City of Portland, Maine - Building or Use Permit Application
 389 Congress Street, 04101 Tel: (207) 874-8703, Fax: (207) 874-8716

Permit No: 08-1580	Issue Date:	CBL: 084 E005001
------------------------------	--------------------	----------------------------

Location of Construction: 8 RYEFIELD ST, Peaks Island	Owner Name: MORGAN PHILIP H	Owner Address: 30 BARKLEY AVE	Phone: 207-786-3102
Business Name:	Contractor Name: Terry Edwards	Contractor Address: 36 Whispering Pines Drive SoPortland	Phone: 2078995737
Lessee/Buyer's Name	Phone:	Permit Type: Additions - Dwellings	Zone:

Past Use: Single Family Home	Proposed Use: Single Family Home - Rebuild existing 6' x 28' porch w/ new foundation - all in original footprint.	Permit Fee: \$140.00	Cost of Work: \$12,000.00	CEO District: 1
Proposed Project Description: Rebuild existing 6' x 28' porch w/ new foundation - all in original footprint		FIRE DEPT: <input type="checkbox"/> Approved <input type="checkbox"/> Denied	INSPECTION: Use Group: Type	
		Signature:	Signature:	
PEDESTRIAN ACTIVITIES DISTRICT (P.A.D.)				
Action <input type="checkbox"/> Approved <input type="checkbox"/> Approved w/Condition <input type="checkbox"/> Denied				
Sign

Drawing file: 1. Original Plans / Existing Plan.pdf

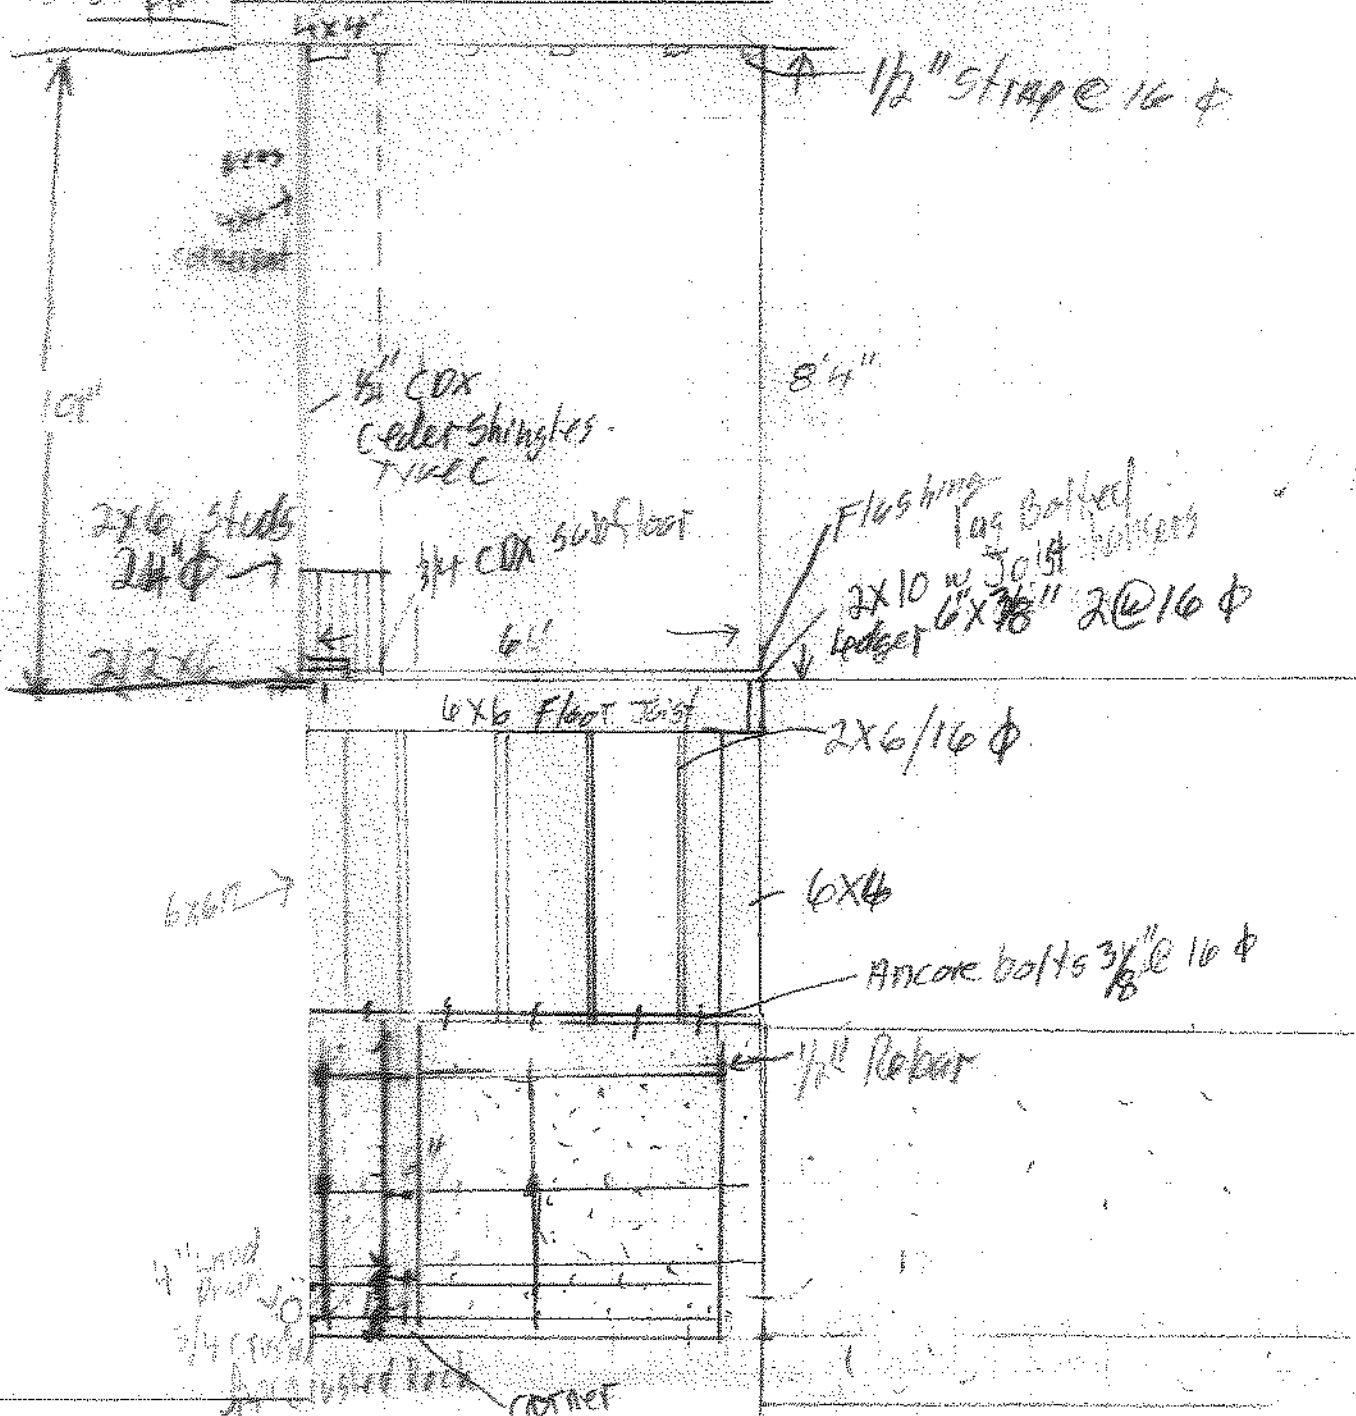
2/25/2009-amachado: Met with Terry Edwards. Went over the new numbers for the volume and floor area within shoreland. Looked at newest proposal for the windows on the enclosed porch. The enclosed porch needs to be at least 50% windows. The proposed plans did not show this. Terry was going to talk to the owner and get back to me.

3/11/2009-amachado: Terry came in today and picked up a "hardship" variance application. The owner does not want to have the enclosed porch be 50% glass.

3/16/2009-amachado: Returned phone call to Terry Edwards. Philip Morgan has decided not to pursue variance. Will not enclose porch at this time. Wants to just rebuild existing porch but will put foundation under it.

3/19/2009-amachado: Terry Edwards came in and revised the permit description. Now he is just rebuilding the original porch with a new foundation. The cost of the work will now be \$6,000 instead of the original \$12,000 that he paid for (\$140). Lisa asked him to bring in the original receipt with a request in writing to have a refund of the difference in the cost of work.
